**Our Case Number:** ABP-316051-23

**Re:** Renewable energy development comprising 9 no. wind turbines and associated infrastructure.  
Umma More and adjacent townlands, County Westmeath.

**Re: SID Reference Number 316051  
Proposed Umma More Wind Farm, Co. Westmeath**

Please find as set out below, our observations on the AASR and NIS in relation to the proposed wind farm comprising 9 no. wind turbines with a blade tip height of 185 meters and all ancillary infrastructure and works, at Umma More and adjacent townlands, Co. Westmeath.

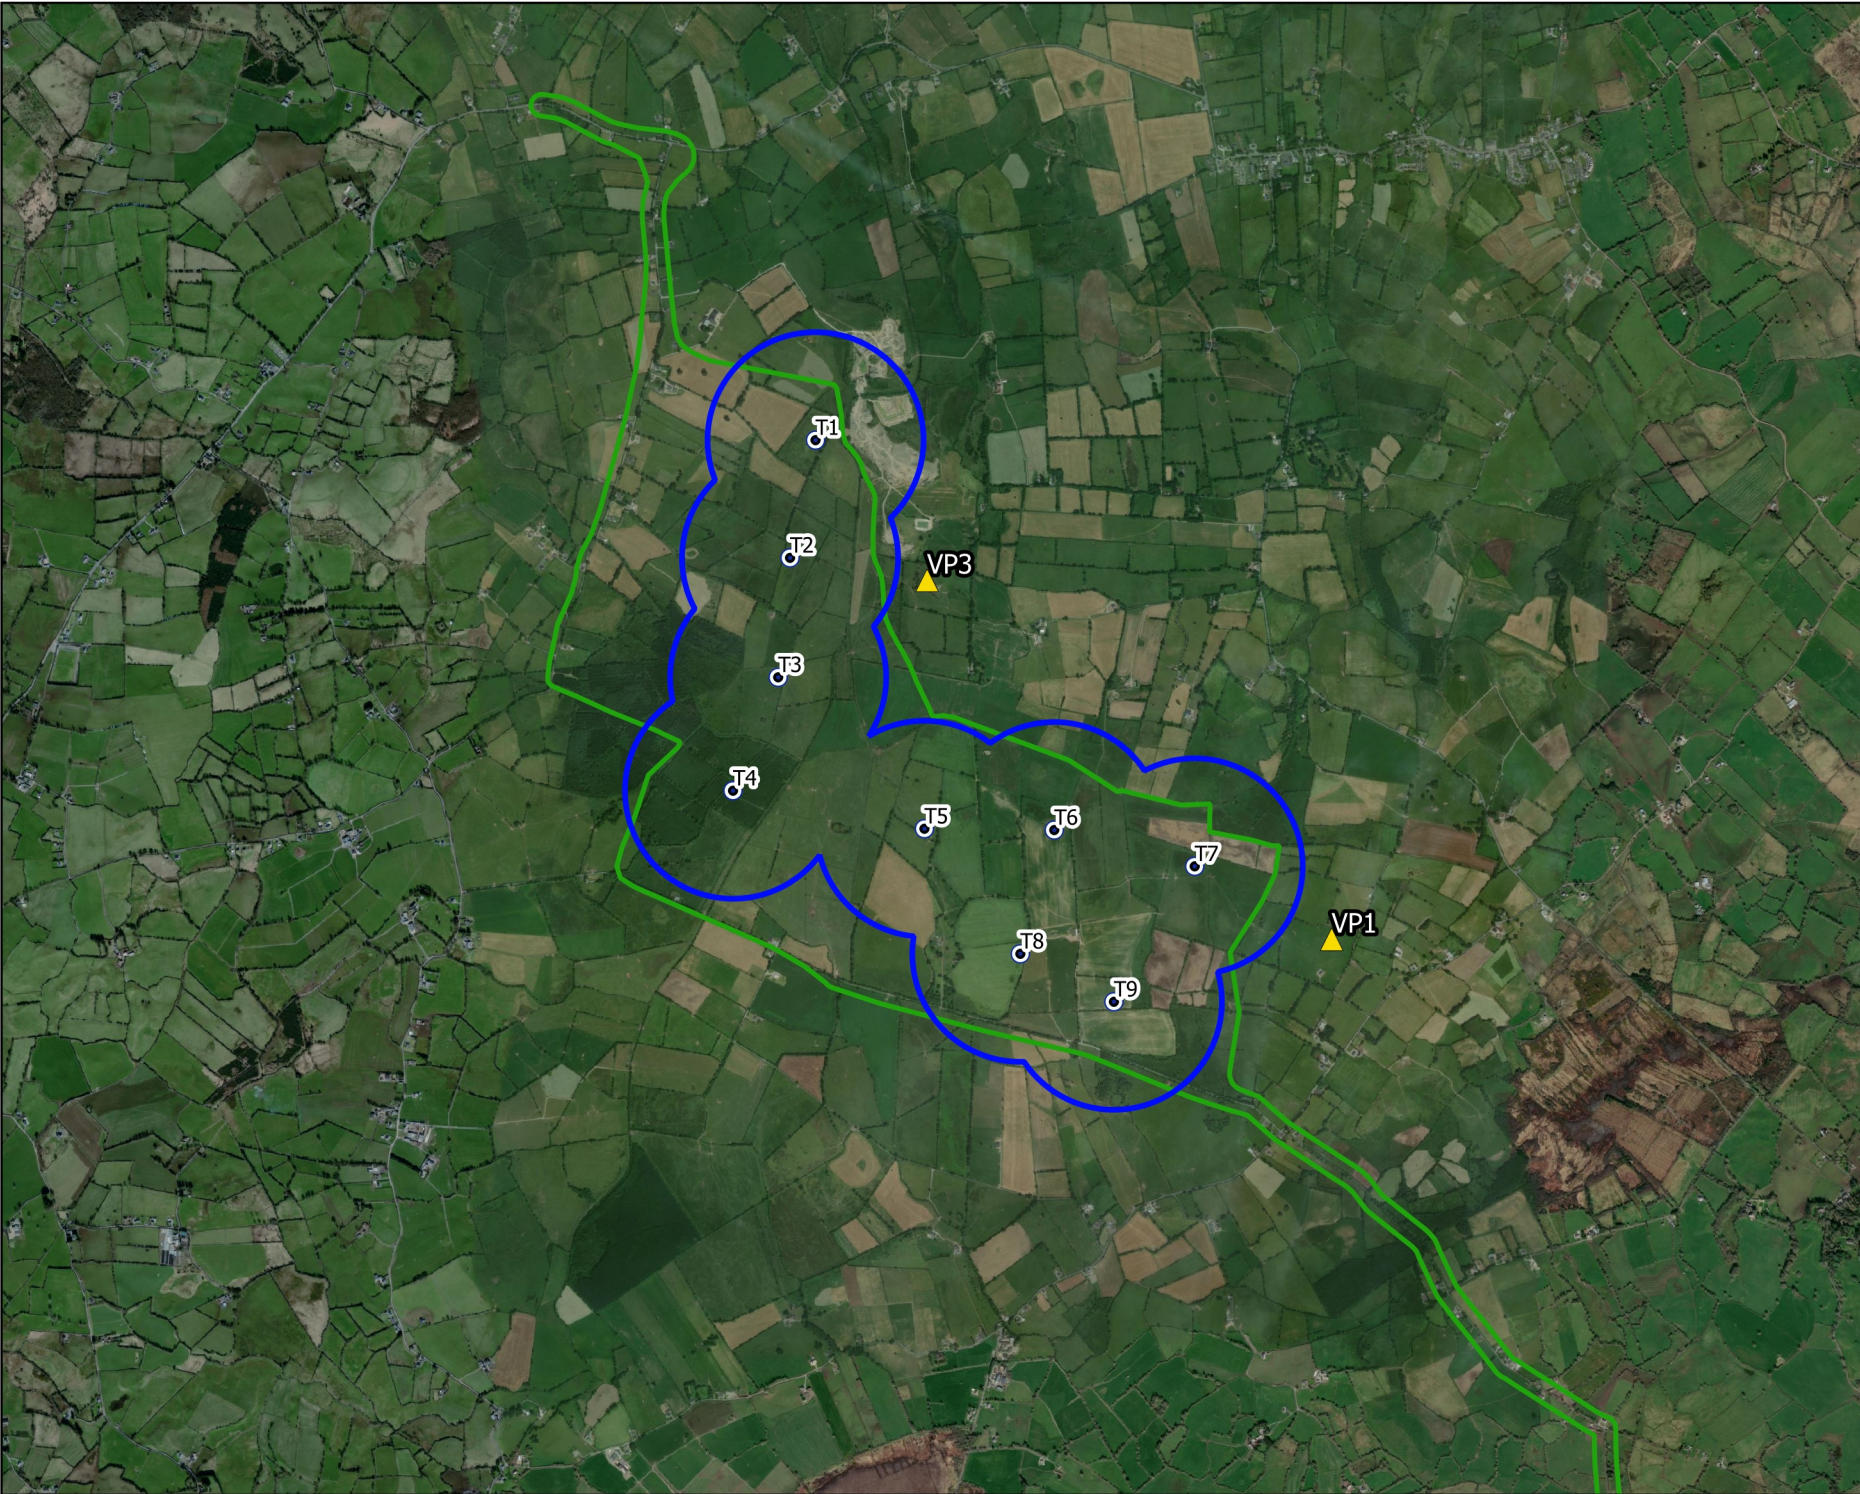
- Vantage Point Locations; Page 15 of 57 of the AASR documents states; *'Data on bird observations and flight activity was collected from a scanning arc of 180° and a 2km radius by an observer at the fixed vantage point locations for two 3-hour watches separated by a minimum 30 minute break (ie. 6 hours total) per month.'*  
Two West facing vantage points VP1 & VP3 with a radius of 2Km were ill-suited for observing species such as the Hen Harrier and Barn Owl who's preferred hunting habitat is rough grassland, hedgerows & field margins & therefore screened from view. The lack of an East facing vantage point resulted in gaps in visibility resulting in the non-detection of significant numbers of noteworthy species. Refer to NIS Appendix 5 Map. Fig. 7.1 Vantage point locations.
